27th March 2018

Change of use of part of public highway for external seating area at front comprising of
4 No. tables & 8 No. chairs. This application may affect the setting of a listed building.
14-18 Surrey Street Littlehampton

Thank you for your internet representation made on 26th March 2018 which has been
recorded as '**an objection**' with the comments as follows:

CLIENT	JD WETHERSPOON PLC		
PROJECT	PUB NO: 534 THE GEORGE INN LITTLEHAMPTON		
DRAWING	PROPOSED PAVEMENT CAFE		
SCALE	A3/1:50	DATE	MAR 2018
PROJECT No	7508	DRAWING No	03
		DRAWN	ALS
		REVISION

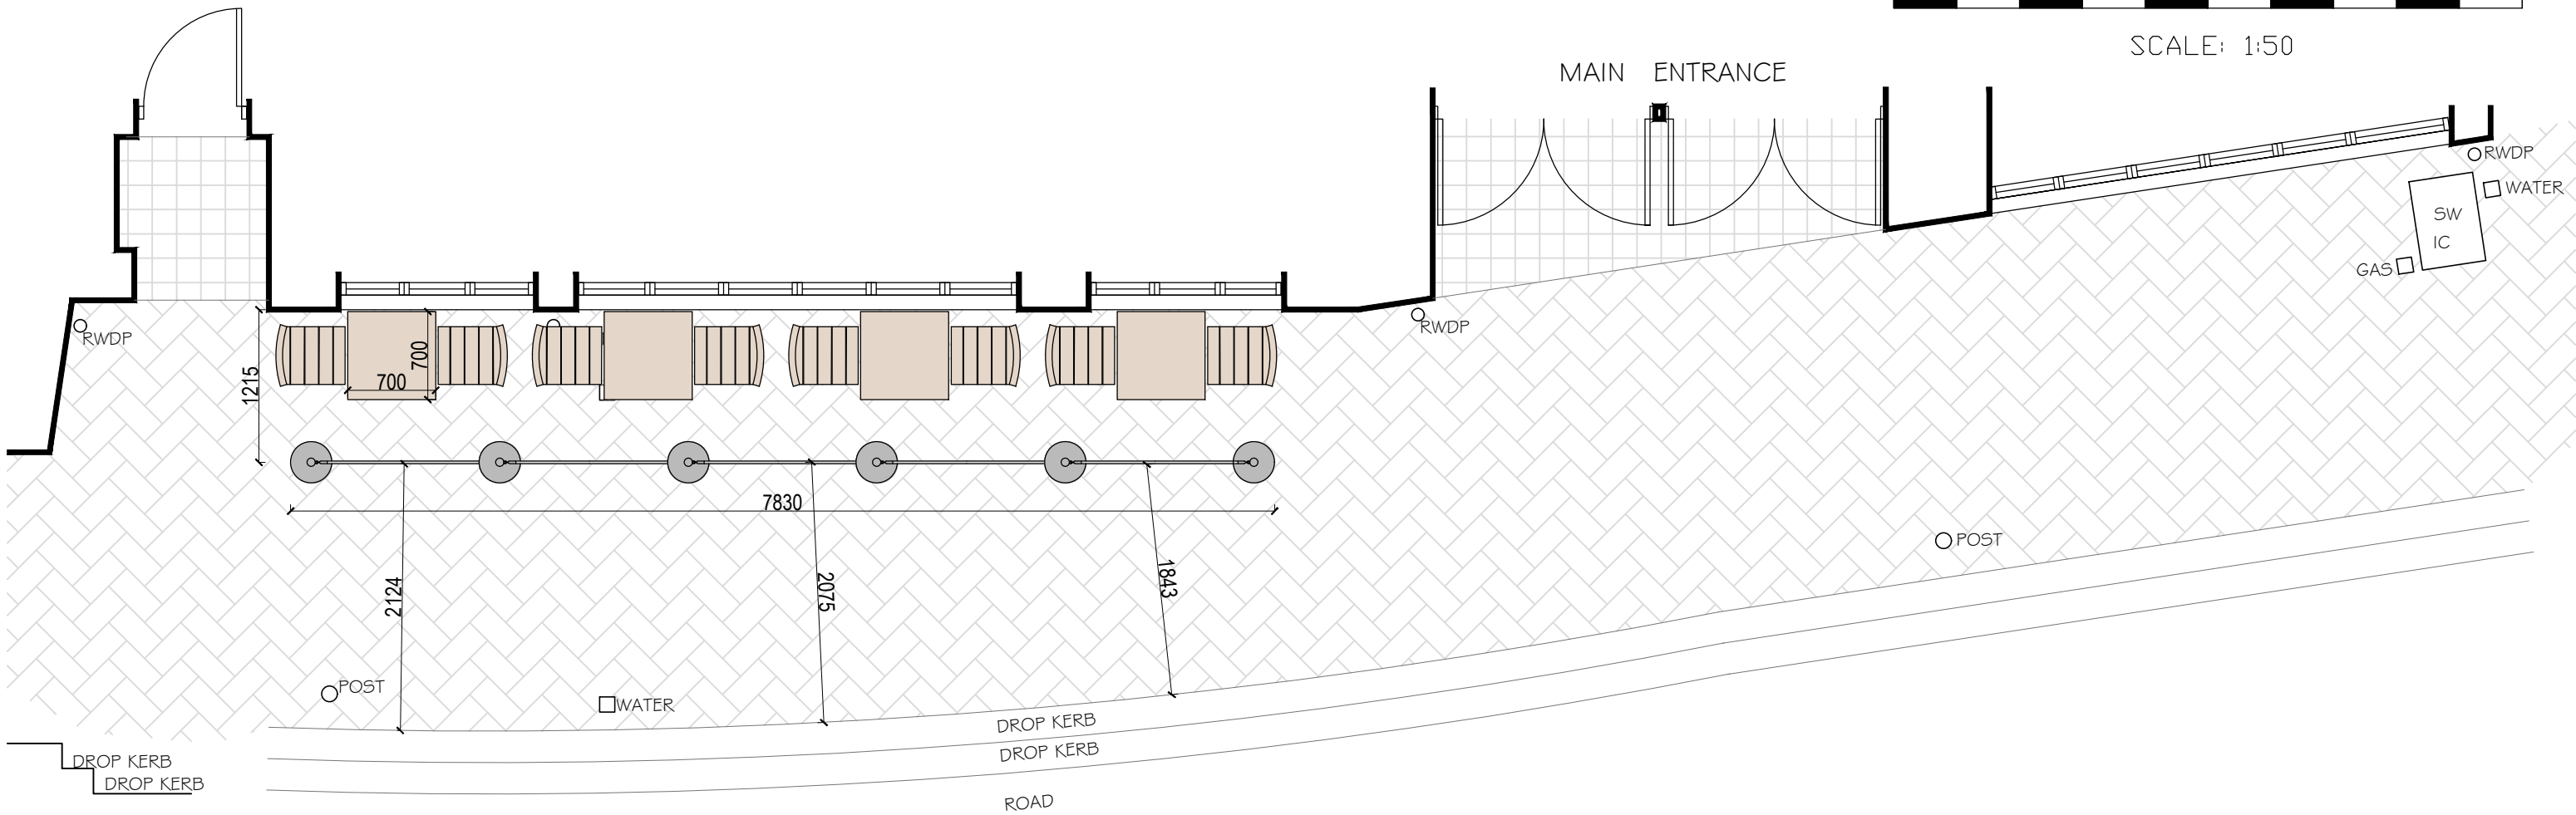
This is not the first time that Wetherspoons have come forward with this proposal. This configuration of 4 tables and 8 chairs is not acceptable nor suitable in this area. We need to think about pedestrians including disabled people in mobility scooters, mums with buggies trying to get passed. The paving slopes away from the pub entrance towards the road with which would make passing these tables and people more dangerous. I would also suggest that this is encouraging on street drinking and we all know how intimidating it can be with people drinking on the street as well as smoking, you can guarantee that not only will you have drinkers sitting but you will have drinkers standing and loitering not forgetting that they already stand outside the main front doors to smoke which is unacceptable not least the cigarette ends that they leave behind. This proposed area is not wide enough nor is it suitable for tables and chairs and is not required.
